Submission No.			137		
Organisation Name or Name of Submitter			James Wickham		
Item No.	Section Ref.	Page No.	Observation Statement	TII Response	
Re: Case reference: NA29N.314724 - MetroLink. 314724: Estuary through Swords, Dublin Airport, Ballymun, Glasnevin and City Centre to Charlemont, Co. Dublin					
1	Introduction	1	<b>Introduction</b> This observation is to support the construction of MetroLink as soon as possible. However, there needs to be recognition that it is a second-best project which results from the political failure to recognise the necessity for substantial and sustained rail investment in the GDA (Greater Dublin Area).	<p>TII thank you for your submission and stated support for the delivery of MetroLink. TII as the Government Agency responsible for delivering MetroLink, are committed to expediting the delivery of this transformative project on receipt of an Enforceable Railway Order.</p> <p>EIAR Chapter 7 (Consideration of Alternatives) details the decision-making process that has led to the development of the proposed Project, including the assessment of alternative modes of transport such as rail. The assessment identified an Optimised Metro North (LR7) as the

Option 9

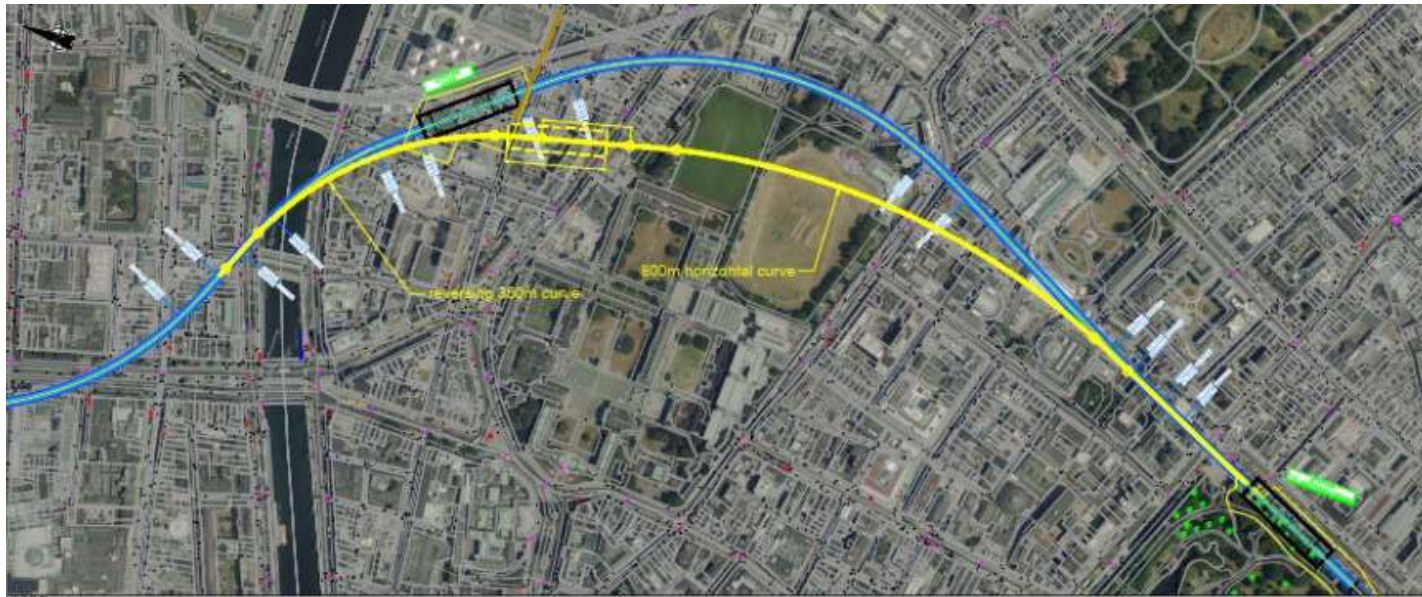
2	Outstanding controversies: (1) Tara Street and Stephens Green	1	<b>Outstanding controversies: (1) Tara Street and Stephens Green</b>  Both of these are changes from the original plans for Metro North as originally approved by ABP which had no Tara Street station and Stephen's Green station was on the West side of the Green. These changes have been partly justified in terms of reducing construction disruption, but appear in fact to derive from the assumption that Dart Underground (the ‘Interconnector’) will never be built. This necessitates some interchange with suburban rail, hence the Tara Street station. Given the effective abandoning of Stephens Green as an underground station for the Interconnector the Stephen's Green Metrolink station can be more easily constructed on the East side of the Green. It is claimed that this ‘interconnects’ with the Luas but this is an exaggeration and stretches the meaning of ‘interconnection’. Passengers wishing to change from Metrolink to Luas will have to walk the length of Stephens Green in the open air.	<p>As outlined by EIAR Chapter 3 (Background to the MetroLink Project) one of the key objectives of the Project is the integration of it with the wider transport network that also includes for BusConnects and DART+ which are all included under Project Ireland 2040. Together, these projects will result in a reliable, sustainable, affordable, integrated public transport network that will support the economy, help Ireland meet its climate change targets in line with Climate Action Plan 2023 and make Dublin a more liveable and sustainable city. A station at Tara Street provides good interchange opportunities, serves important key trip attractors in the study area with high potential passenger trips. This option also takes a direct and short route through areas of high demand in the centre of the study area.</p> <p>A station on St Stephen’s Green West is not preferred for several reasons:</p> <p>If a station was placed on St Stephen’s Green West, the alignment between the proposed Tara Station and a station on St Stephen’s Green West would result in an undesirable horizontal reverse curve and an alignment greater than 1000m long that would necessitate an intermediate intervention shaft located somewhere between these stations to comply with the MetroLink Fire Strategy. Additional construction would be required to provide such a facility, similar in size to the proposed Albert College Park Intervention shaft. This could feasibly be situated in the Trinity College Dublin sports grounds but would import additional environmental impacts and cost.</p> <p>TII note that it is Government policy to provide a station and interchange with the Luas Green Line at Charlemont, as set out by the GDA Transport Strategy 2022 – 2042. Should a station be placed on St Stephen’s Green West, the alignment between a station located here and the proposed Charlemont Station would also result in an undesirable horizontal reverse curve and an alignment that is greater than 1000m long, and would thus again require an intervention shaft similar to the proposed Albert College Park Intervention shaft to be provided. This would be expected to result in significant demolition and redevelopment in an existing built-up area.</p> <p>In both cases, compared to the proposed alignment that runs much more directly between Tara, St Stephen’s Green and Charlemont, the additional length of tunnel and the addition of two intervention shafts generated by locating a station on St Stephen’s Green West is uneconomic in comparison.</p>

Submission No.			137	
Organisation Name or Name of Submitter			James Wickham	
Item No.	Section Ref.	Page No.	Observation Statement	TII Response
Re: Case reference: NA29N.314724 - MetroLink. 314724: Estuary through Swords, Dublin Airport, Ballymun, Glasnevin and City Centre to Charlemont, Co. Dublin				
				<p>As a potential station location, St Stephen’s Green West itself is a very constrained location due to the presence of buildings, Luas and St Stephen’s Green Park. Maintaining the operation of the Luas during station construction would be complex and challenging with significant disruption expected, whilst the impacts on St Stephen’s Green Park would be greater for a station in this location compared to the proposed location on St Stephen’s Green East. This would be the result of; the likely need to place more of the station in the Park compared to the proposed station on St Stephen’s Green East; it would impact an area of the Park that has greater amenity value than St Stephen’s Green East due to the nearby Park entrance adjacent to the southern end of Grafton Street, and there would be a risk of impacting the existing Park lake.</p> <p>In summary, an alignment that links the proposed Tara, St Stephen’s Green East and Charlemont stations is a more direct and economic alignment, does not require additional intervention infrastructure, avoids a complex engineering interface with the Luas Green Line, impacts the Park less and has less potential for disruption during the construction phase.</p> <p>It is acknowledged that passengers wishing to interchange between Luas and MetroLink at the St. Stephen’s Green station will have a 500m-walk along a route either through St Stephen’s Green Park or along the footpath north of the park. The interchange time is calculated at 7.58 minutes. However, the interchange arrangements at Charlemont provide for a significantly better connection with Luas compared to St. Stephens Green Station, where the interchange time is calculated at 2.9 minutes. Interchange times and routes are detailed in Appendix A7.9 (Terminus Station at Charlemont compared to St. Stephen’s Green).</p>
